From: Niland, Mark
Sent: 04 August 2025 09:49
To: _planningadvice
Subject: FW: Land At Peartree Hill Road - South Holland

H23-0313-25 - Land At Peartree Hill Road

Following the re-consultation for this major application I comment as follows: -

ACCESS PLAN
Scale 1:200

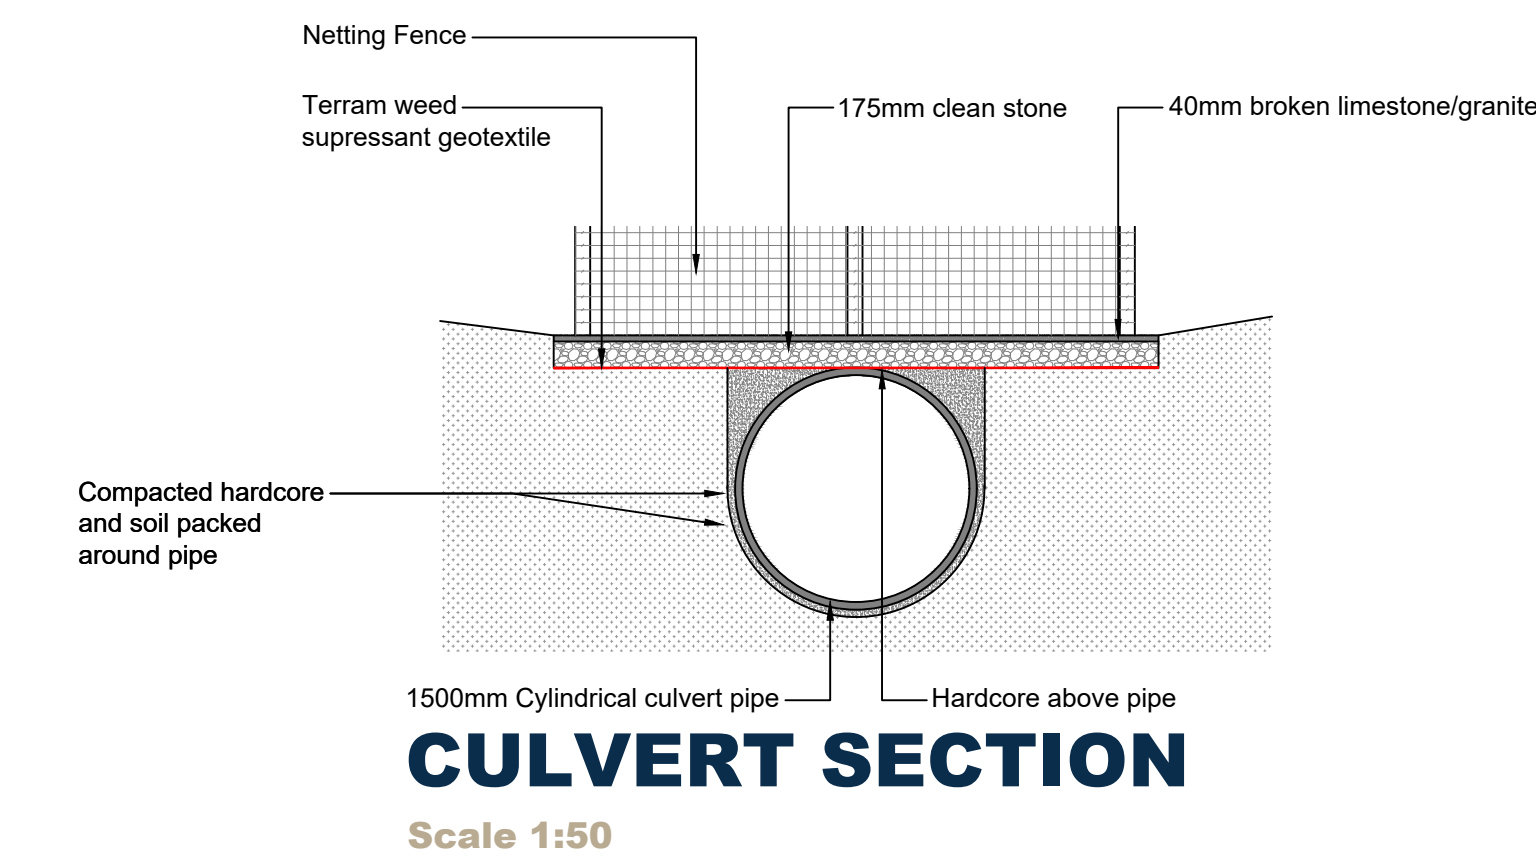
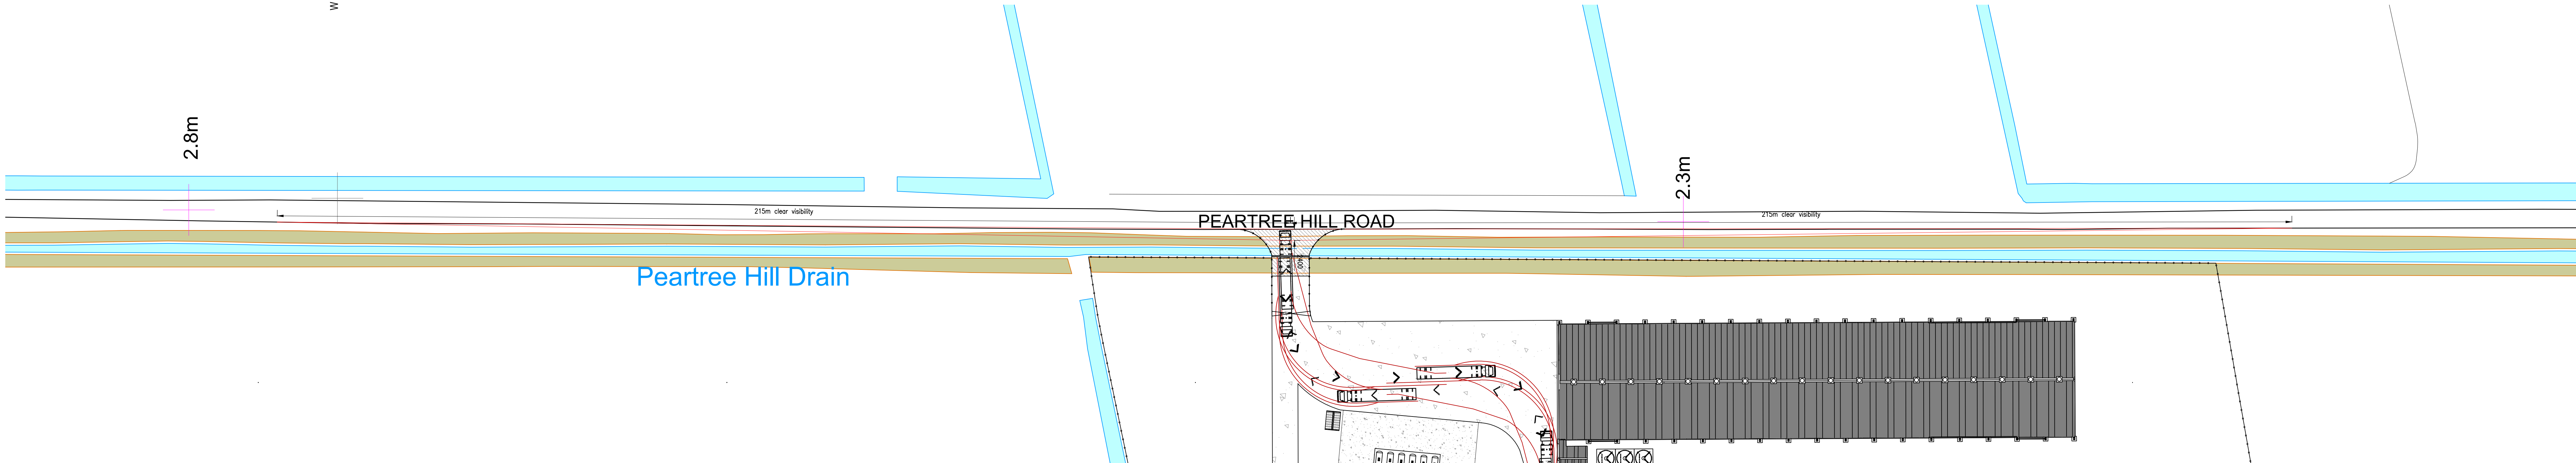
What is the distance from the carriageway edge to the gate? **This needs to be detailed on the proposed site plan**

The access is to be constructed to Lincolnshire County Council Specification and a note should be added to the proposed site plan. Visibility is to be demonstrated in accordance with Manual for Streets. **Visibility is detailed in the statement but not demonstrated on plan. The Spec should be detailed on the site plan.**

The post and rail fencing should not abut the carriageway – it should only go up to the field boundary and should not restrict visibility. **Outstanding**

ACCESS PLAN

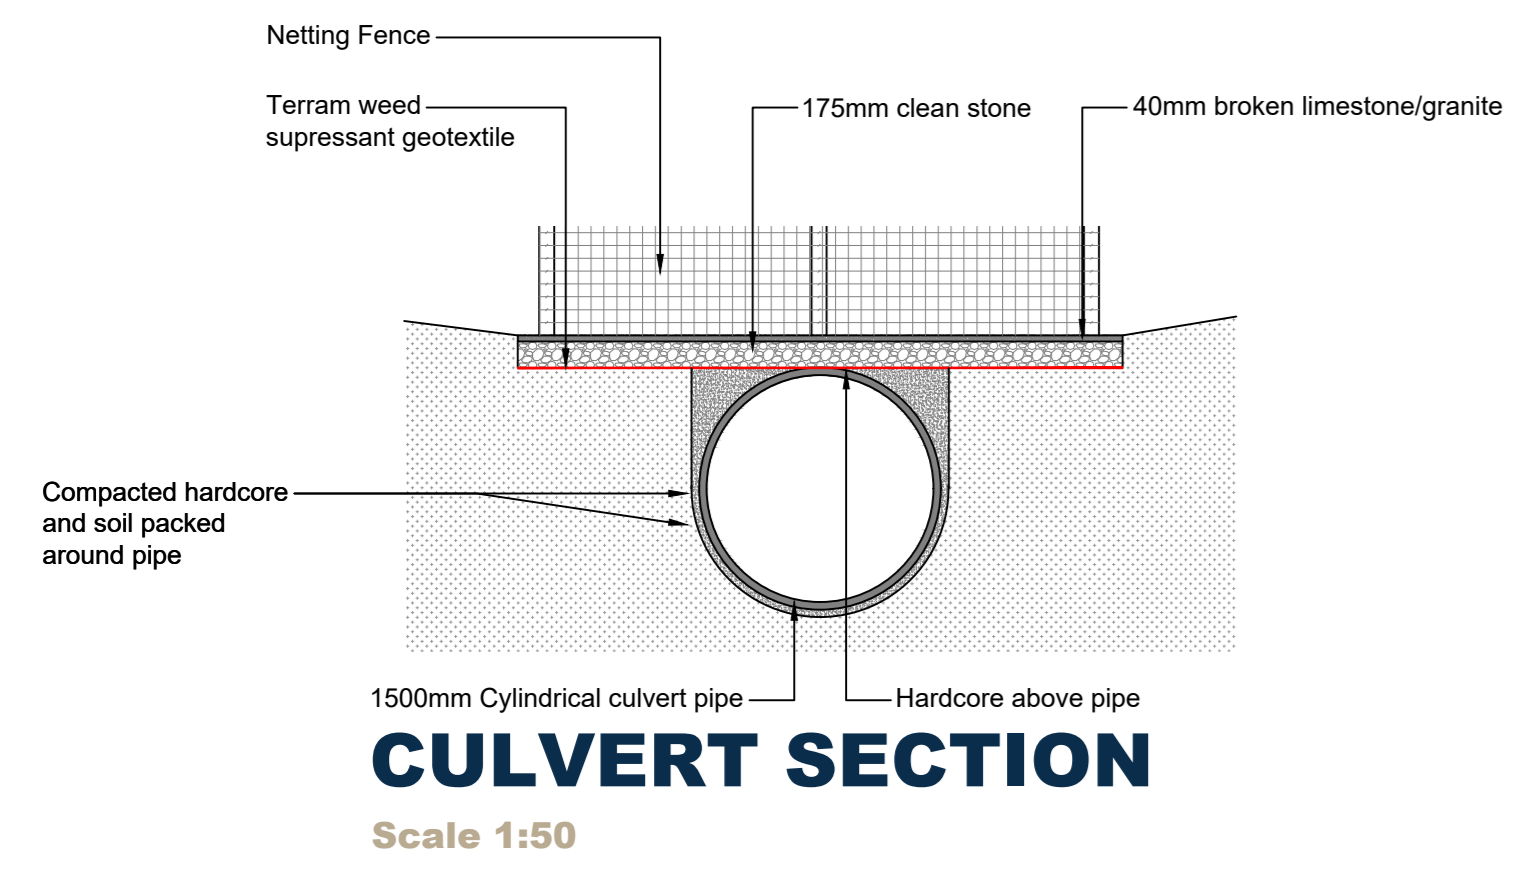
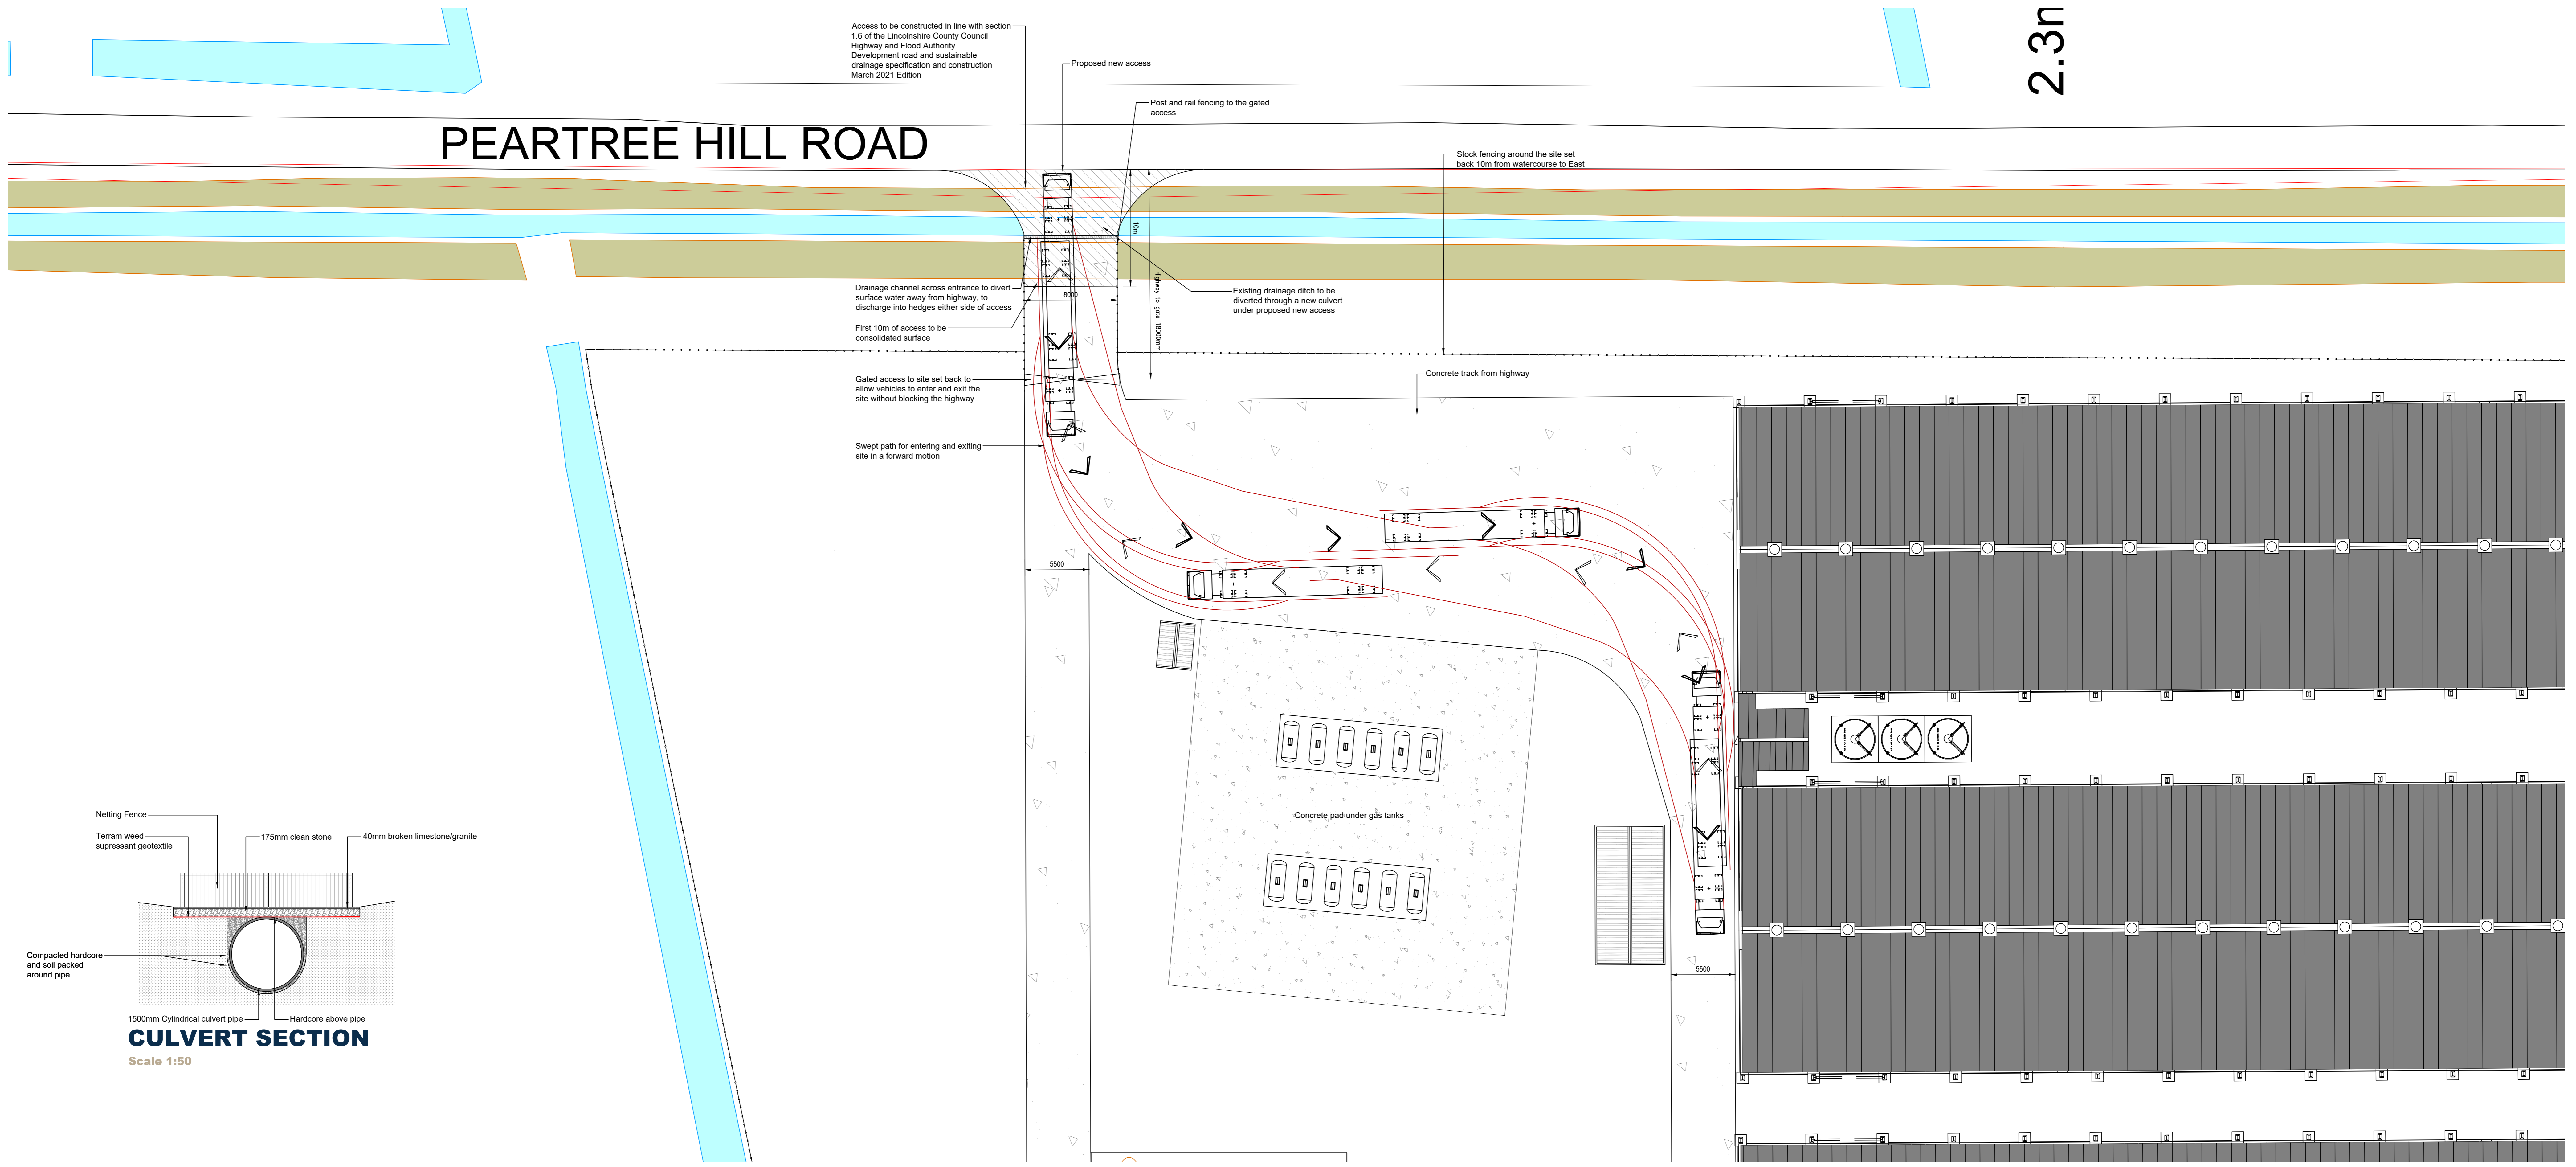
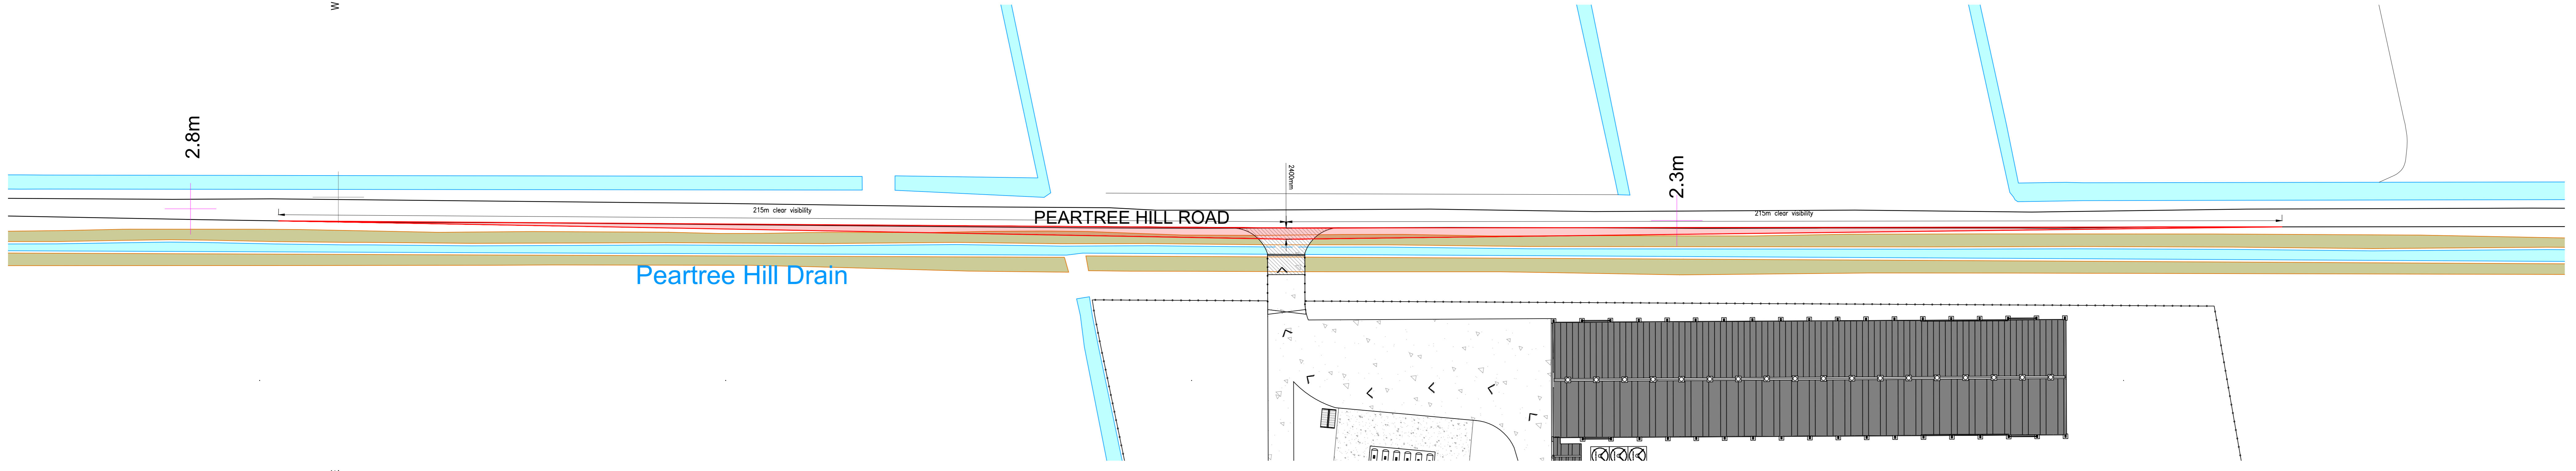
They have referred to the Development Management Roads spec not S184 - it needs to read to Lincolnshire County Council Specification. This is a Section 184 under the Highways Act 1980 and will be to a heavy-duty specification.

Visibility splay is unclear - should measure from 2.4m back from the carriageway edge along the sight line.

The stock fencing is shown in the public highway. The verge fronting the watercourse is highway and the fencing should not be installed here.
